**WEST SUSSEX COUNTY COUNCIL
HIGHWAYS AND TRANSPORT SERVICES CONSULTATION**

SUBJECT: EG/79/07 – Proposed new dwelling and garage

ADDRESS: Lyndhurst Eastergate Lane Eastergate PO20 3SJ

Proposed Garage Layout (As shown on Block Plan)

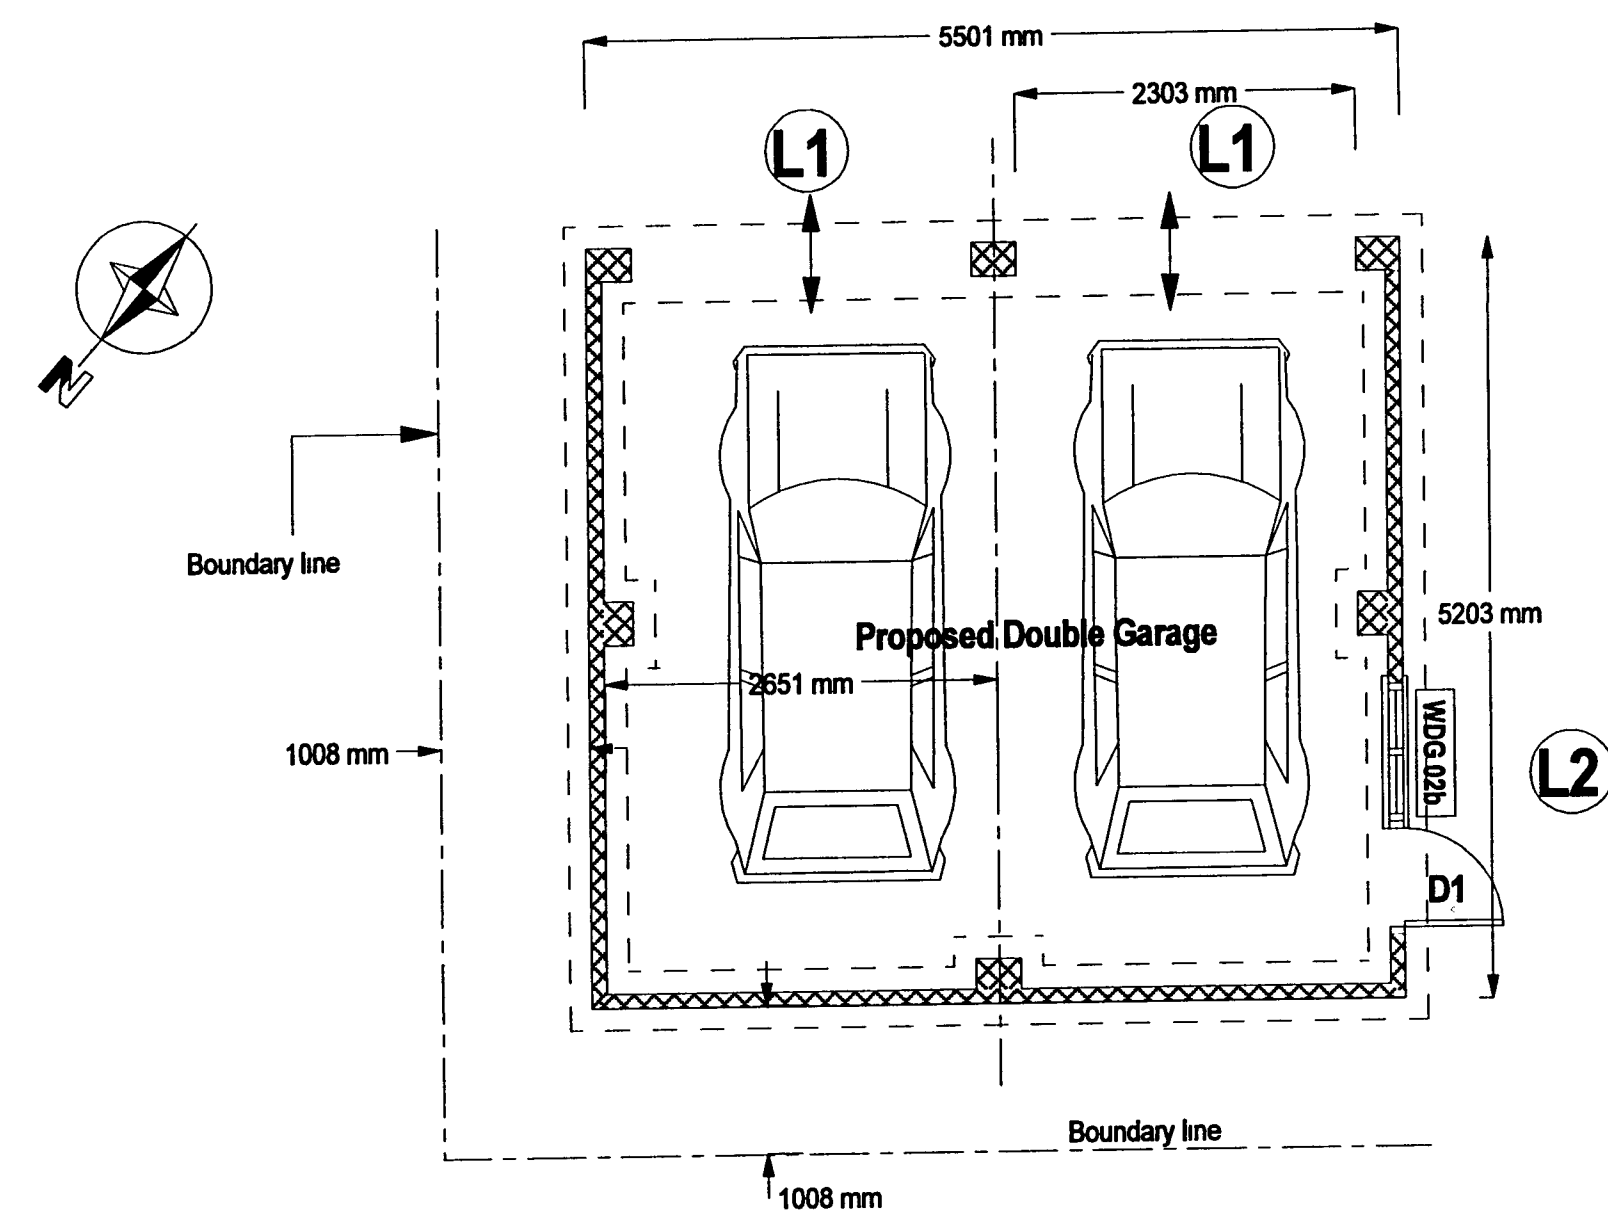
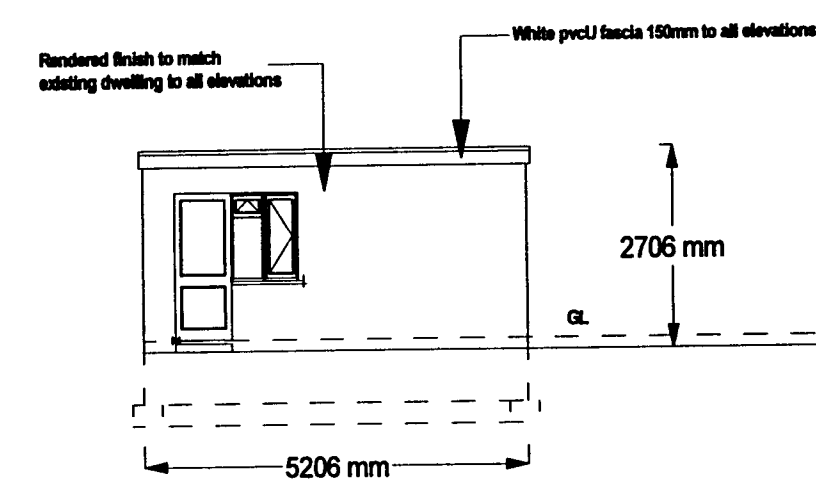
It should be noted that although not explained in detail on the plans, from data provided it is believed that, as the egress from the proposed garage is to the southeast, the existing driveway of Lyndhurst will be used for the purposes of both houses. As long as this is the case, no highway objection would be raised to this application.
